CITY OF ALBUQUERQUE

December 9, 2013

**Re: Dental Office, 7500 Holly Ave. NE
Grading and Drainage Plan,
Engineer's Stamp Date 11/26/2013 (C-19/D058)**

## GRADING AND DRAINAGE PLAN

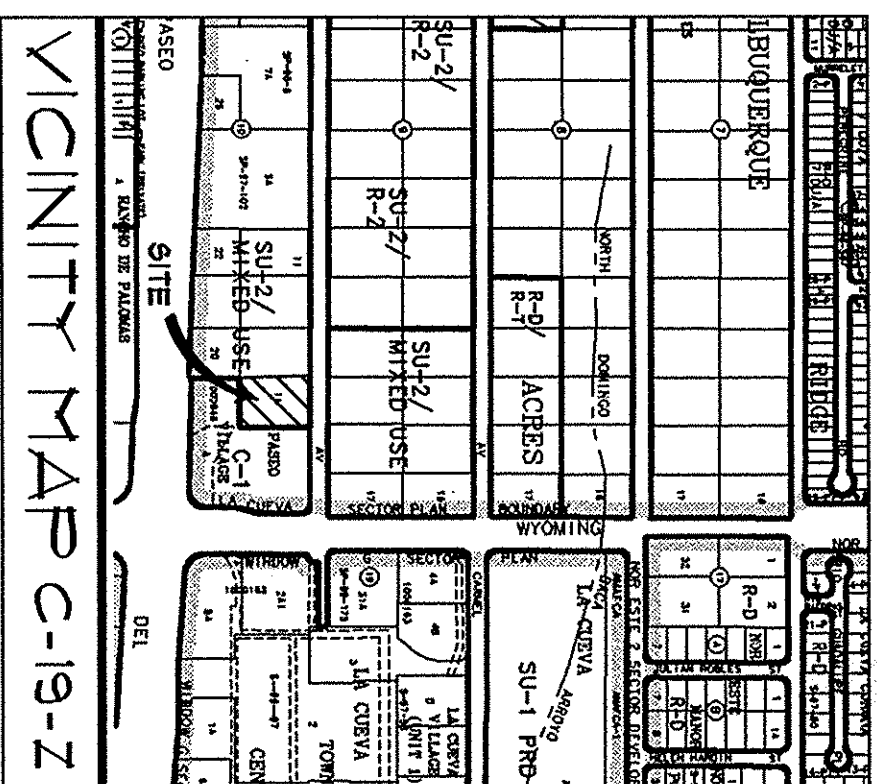
- Show the handicap parking spaces and as-built grades as part of certification.
- Extended stem wall may be required at the northeast corner of the northerly building. Grades steeper than 3:1 will require slope treatment.
